STAFF REPORT

SHORELINE SUBSTANTIAL DEVELOPMENT PERMIT

Project No.:	SHL23-025
Description:	A request for a Shoreline Substantial Development Permit with SEPA Review for the construction of a new 552 square foot, fully grated private single-family pier and relocation of an existing boatlift.
Applicant / Owner:	Troy Hussing (Ecco Design Inc.) / O'Neil Generation Trust
Site Address:	4452 Ferncroft Rd, Mercer Island, WA 98040; Identified by King County Assessor tax parcel number 004610-0405.
Zoning District:	Single Family Residential (R-15)
Staff Contact:	Molly McGuire, Planner
Exhibits:	<ol style="list-style-type: none">1. Development Application, received by the City of Mercer Island on April 6, 20232. Revised Development Plan Set, dated August 25, 2023 and received October 26, 20233. Revised Project Narrative, received October 26, 20234. Revised SEPA Checklist, received October 26, 20235. City of Mercer Island SUB1 Review Comments, dated May 30, 20236. Applicant Response to City of Mercer Island SUB1 Review Comments, dated August 28, 20237. City of Mercer Island SUB2 Review Comments, dated September 26, 20238. Applicant Response to City of Mercer Island SUB2 Review Comments, dated

**PROPOSED SITE PLAN**  
SCALE 1" = 30'-0"

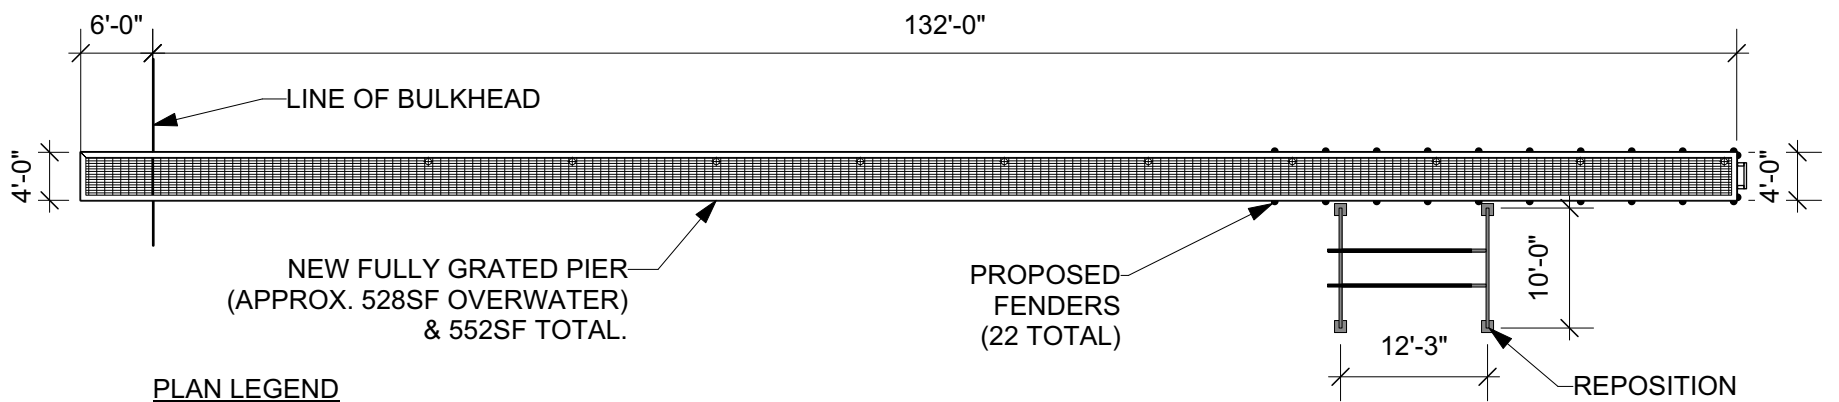
Staff Analysis: The proposed moorage facility would extend approximately 132 feet waterward from the OHWM (**Exhibit 2, Sheet 4**). Based on the plan set, the dock does not extend beyond the point where water depth is 11.85 feet at OHWM; therefore, this requirement is met.

Staff Analysis: The proposed moorage facility would not exceed 4 feet in width within 30 feet waterward from the OHWM (**Exhibit 2, Sheet 4**); therefore, this requirement is met.

Staff Analysis: The proposed moorage facility would not exceed 6 feet in width more than 30 feet waterward from the OHWM (**Exhibit 2, Sheet 4**); therefore, this standard is met.

Staff Analysis: The subject property has 70 feet of water frontage on the shoreline (**Exhibit 2, Sheet 4**); therefore, this requirement is met.
